LETTER OF INTENT
Fall Mountain Farm Agritainment Venue
Special Use: Additional Parking
PCD File No. AL2611

July 22, 2026

Site Plan 2026

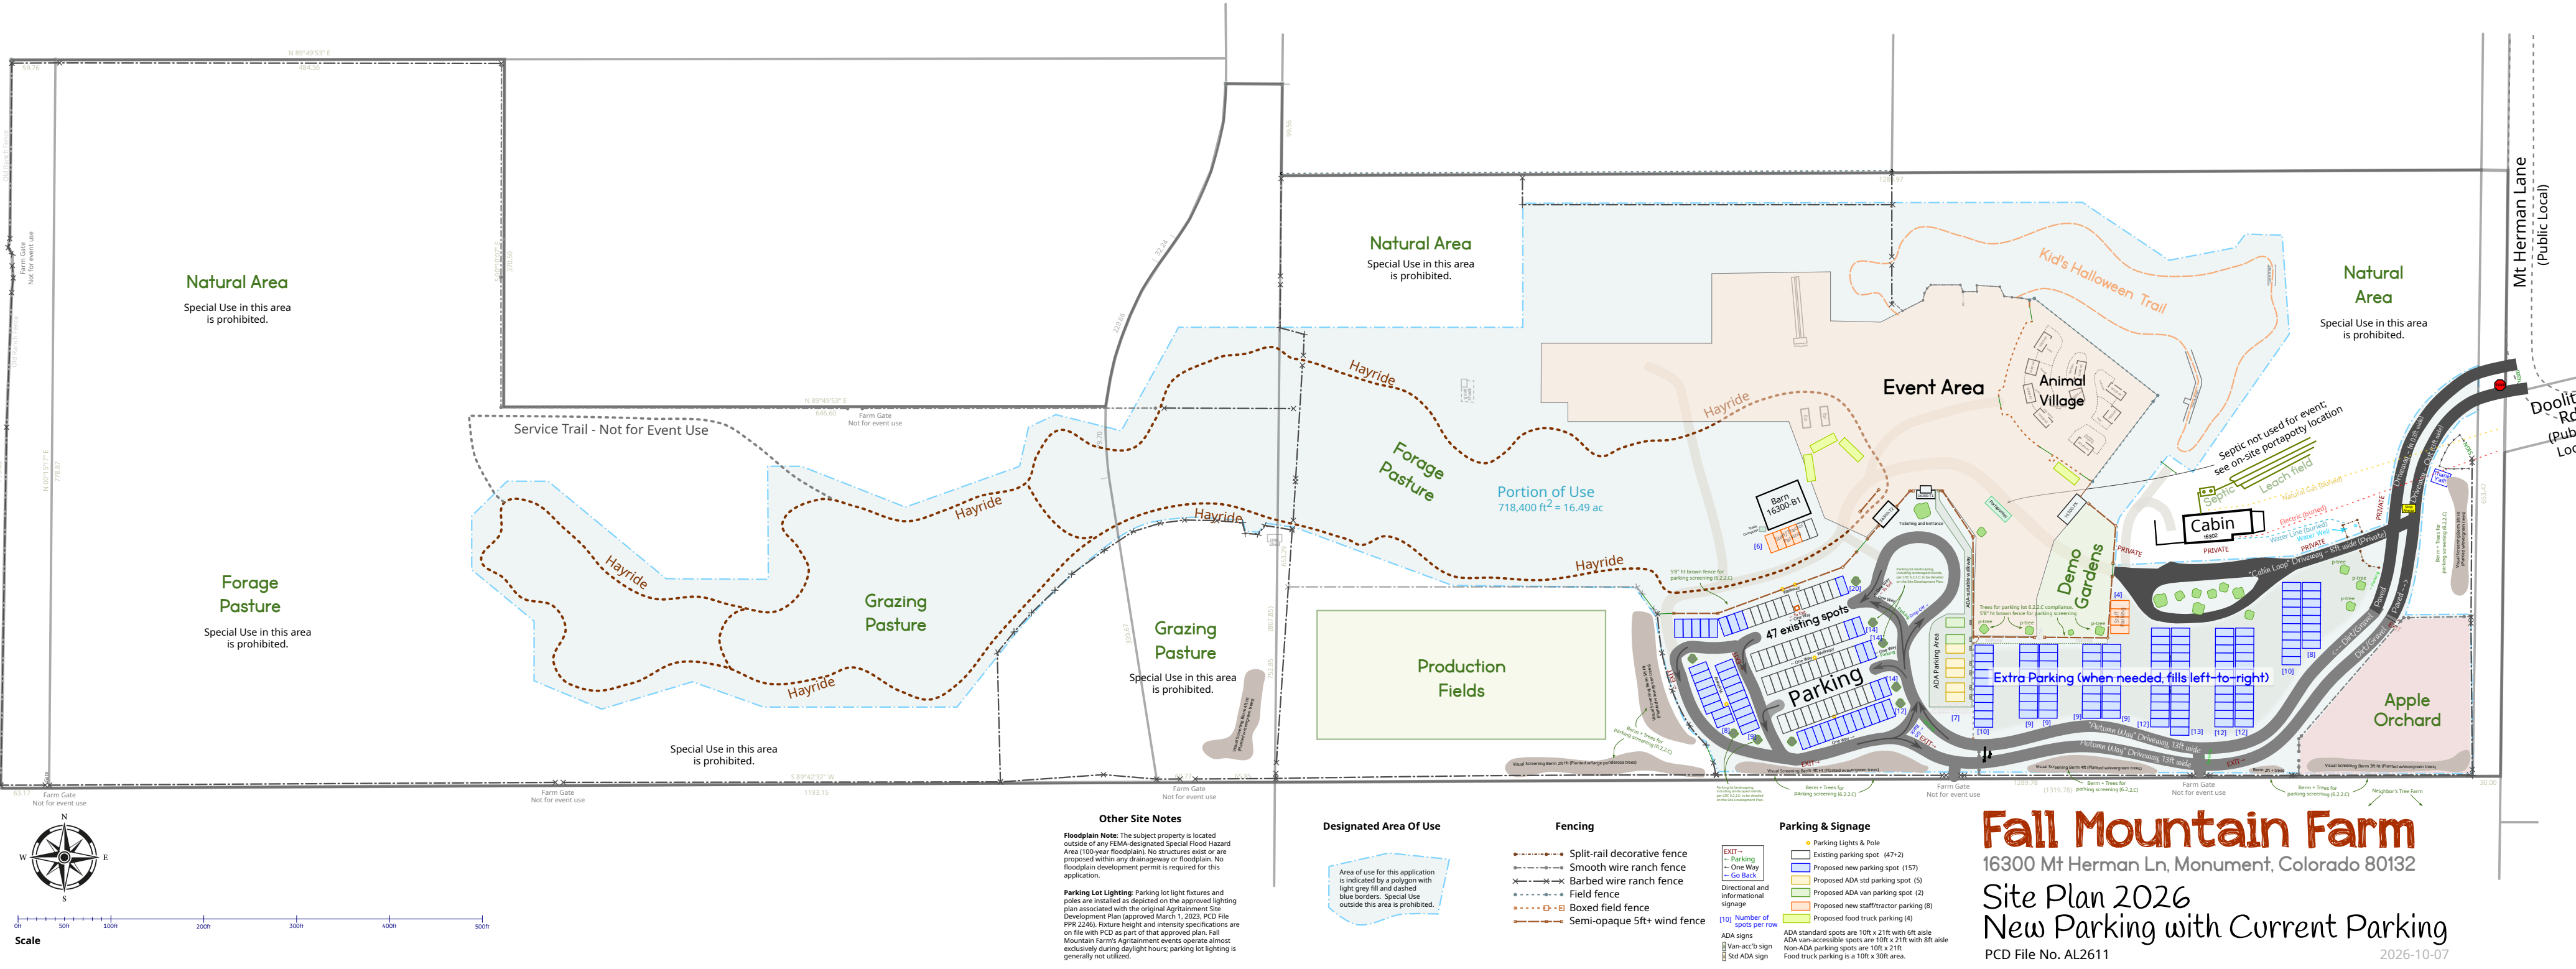
Staff would not recommend showing these on the plans if they are not official record.

Please see comments on the site plan drawing regarding the emergency access and revise LOI/Supplemental Response as needed. I understand the justification presented in this LOI but the County is not able to approve access onto/through adjacent property unless there is a legal joint access and maintenance easement. Feel free to contact engineering if you have any questions.
